SHEET 4 OF 10	SAND CREEK CENTER TRIBUTARY		H-SCALE 1"=20'	1"=20'	No.	REVISION	BY	DATE	<p>UNTIL SUCH TIME AS THESE DRAWINGS ARE APPROVED BY THE APPROPRIATE REVIEWING AGENCIES, JR ENGINEERING APPROVES THEIR USE ONLY FOR THE PURPOSES DESIGNATED BY WRITTEN AUTHORIZATION.</p>
	CHANNEL PLAN AND PROFILES		V-SCALE 1"=2'	1"=2'					
			DATE	08/03/22					
			DESIGNED BY	JBp					
JOB NO.	25174.00		DRAWN BY	JBp					<p>CS POWERS & GALLEY LLC 510 S. NEIL ST. CHAMPAIGN, IL 61820 OFFICE PHONE (734) 216-2577</p>
		CHECKED BY							
						<p>JR ENGINEERING A Westman Company</p>			<p>CENTRAL 303-740-5383 • COLORADO SPRINGS 719-589-2688 FAX 303-970-491-8888 • www.jrengineering.com</p>

SAND CREEK CENTER
TRIBUTARY

DROP STRUCTURE DETAIL
SHEETS

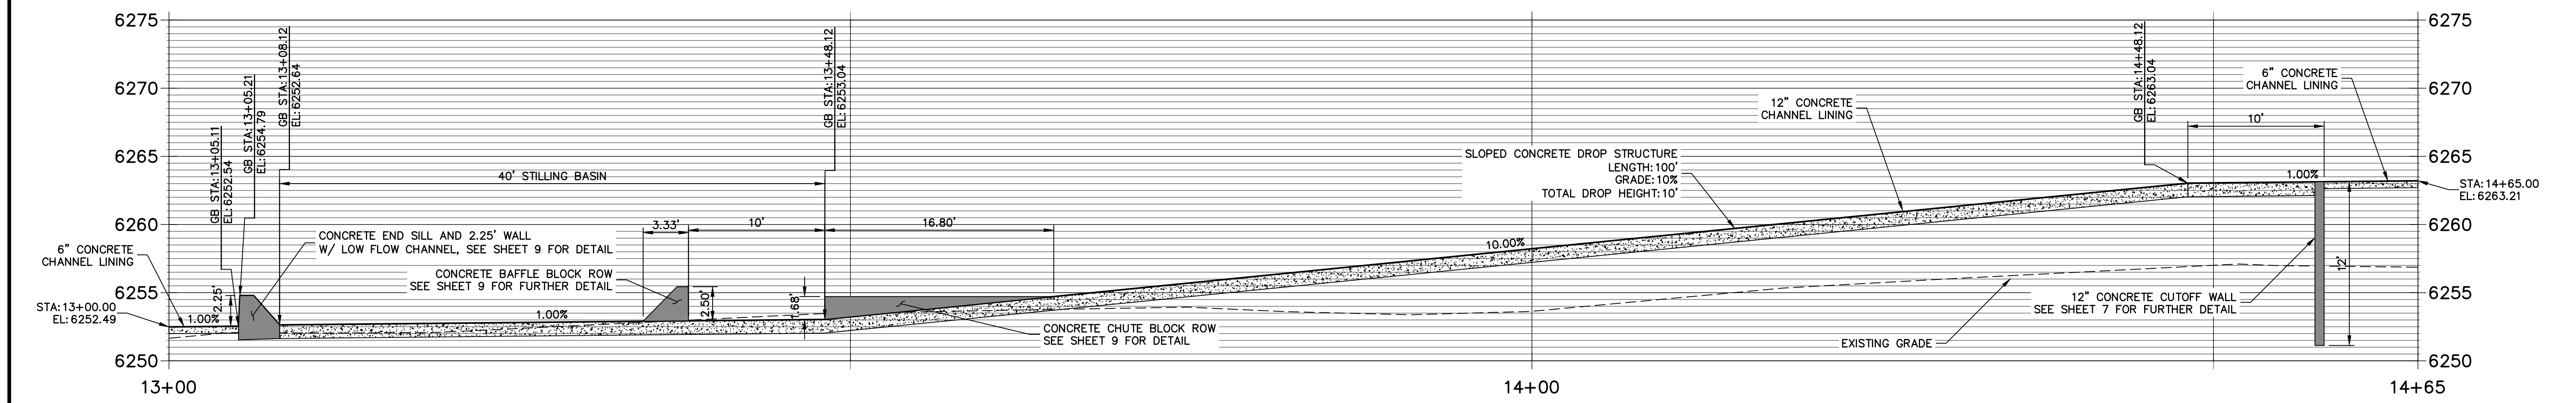
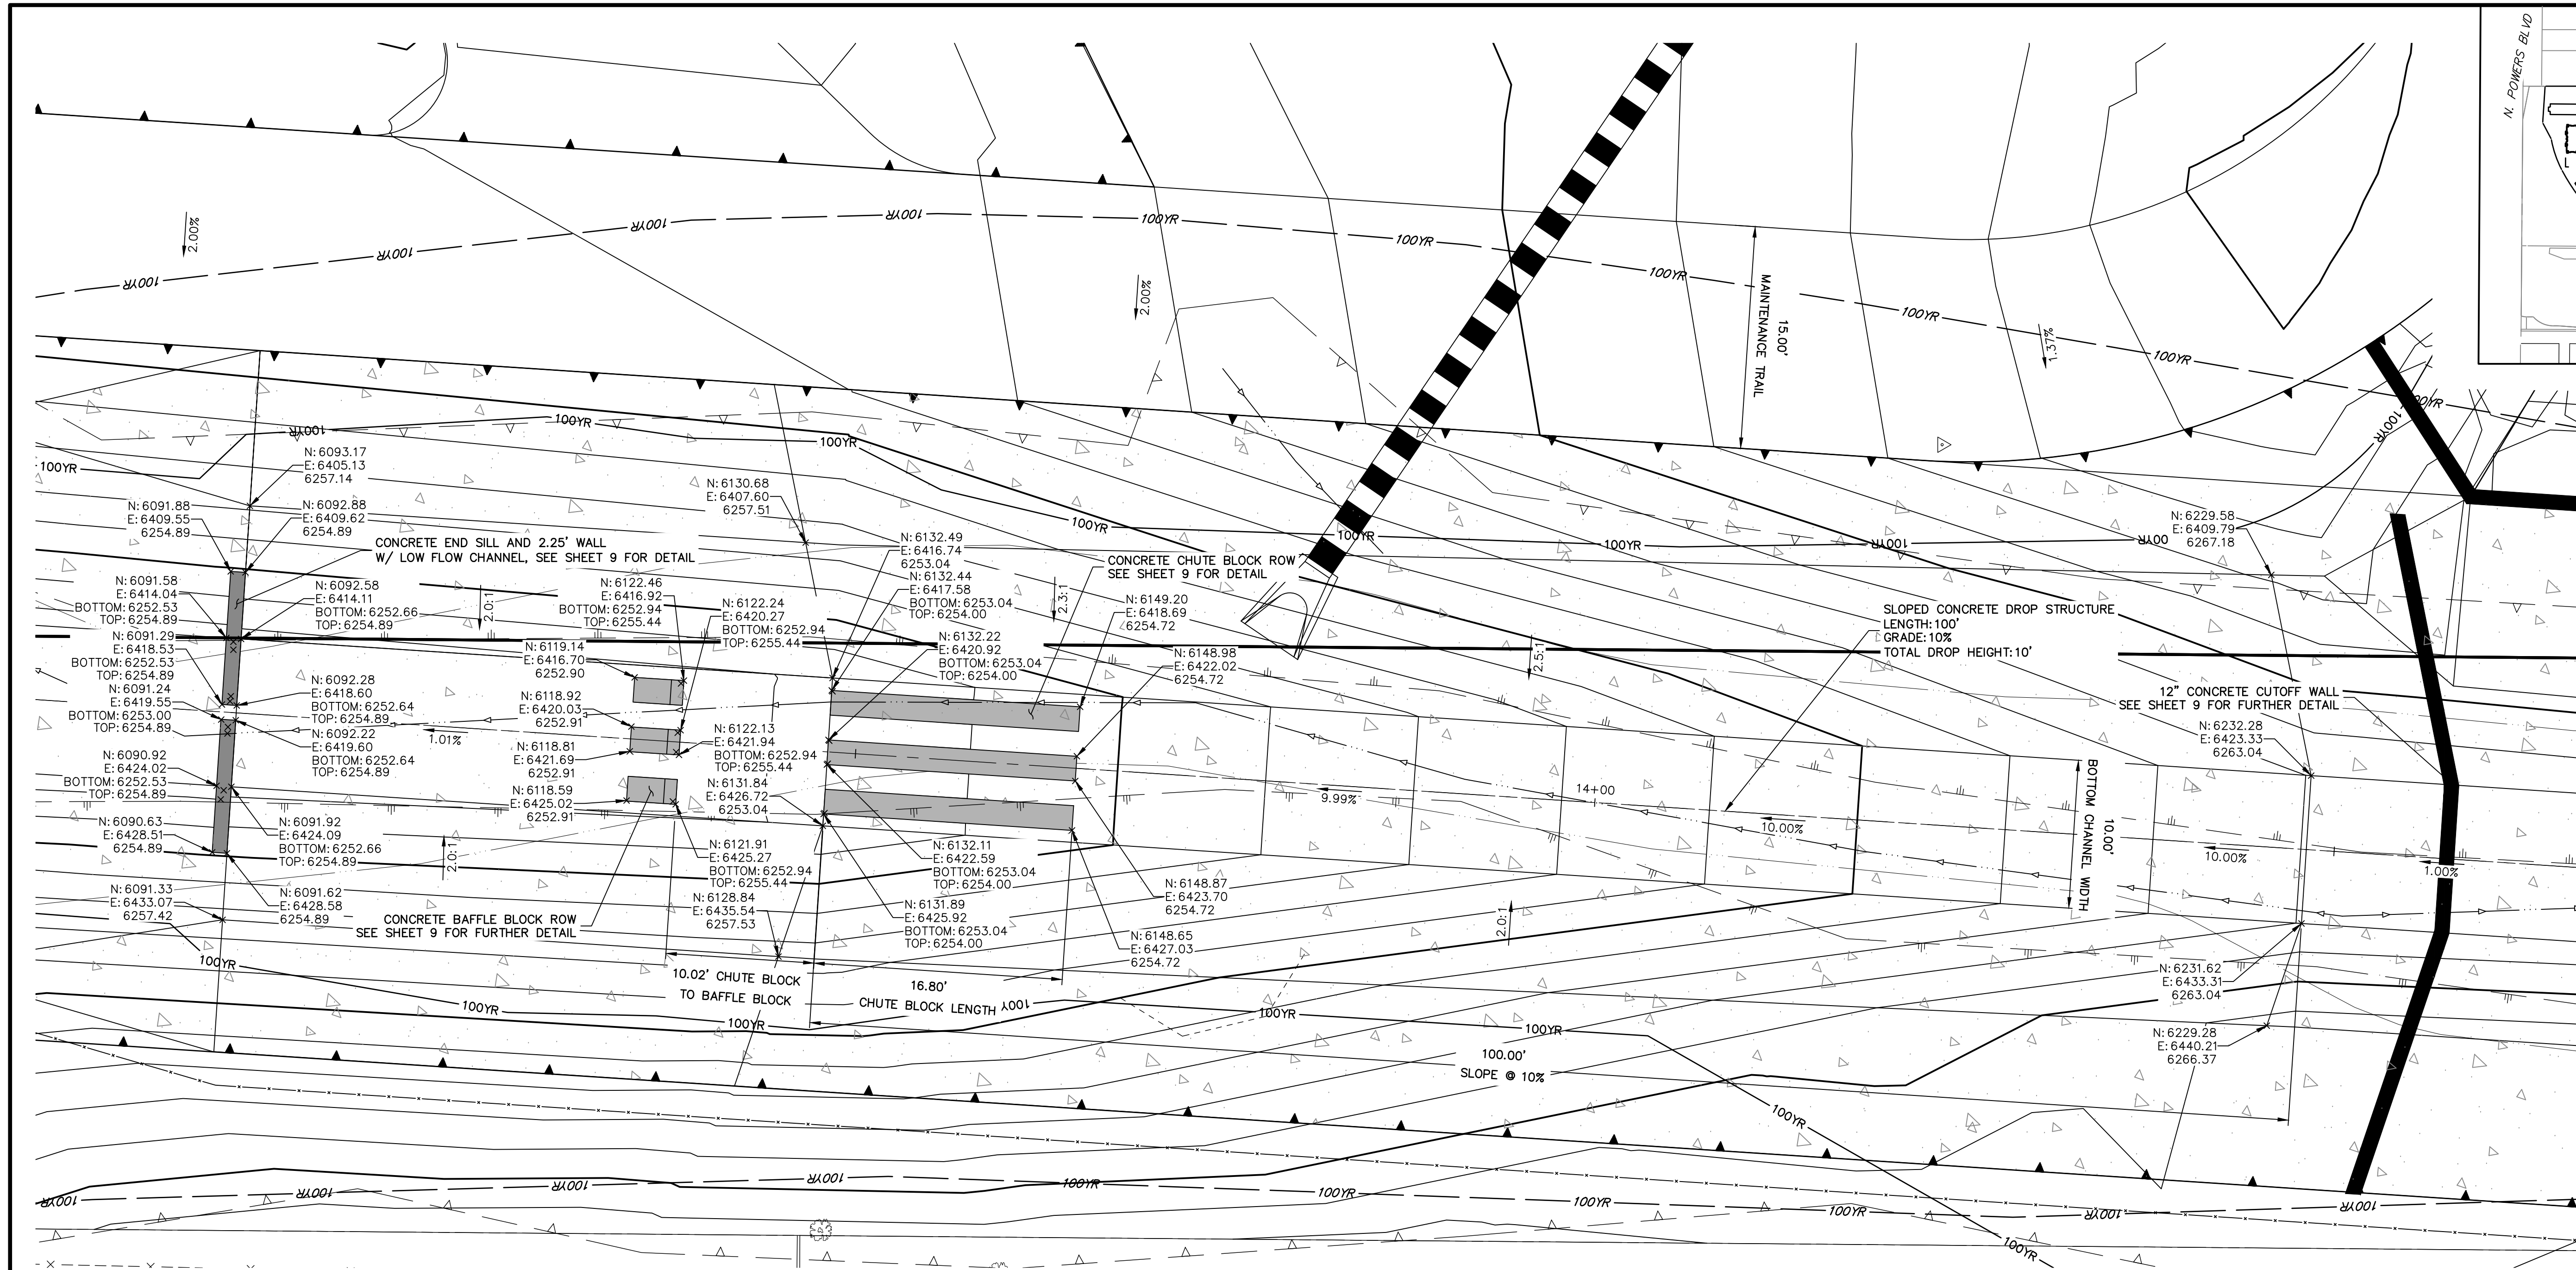
Please also provide an updated drop structures plan and profile sheet (sheet 8 of 10 of original plans)
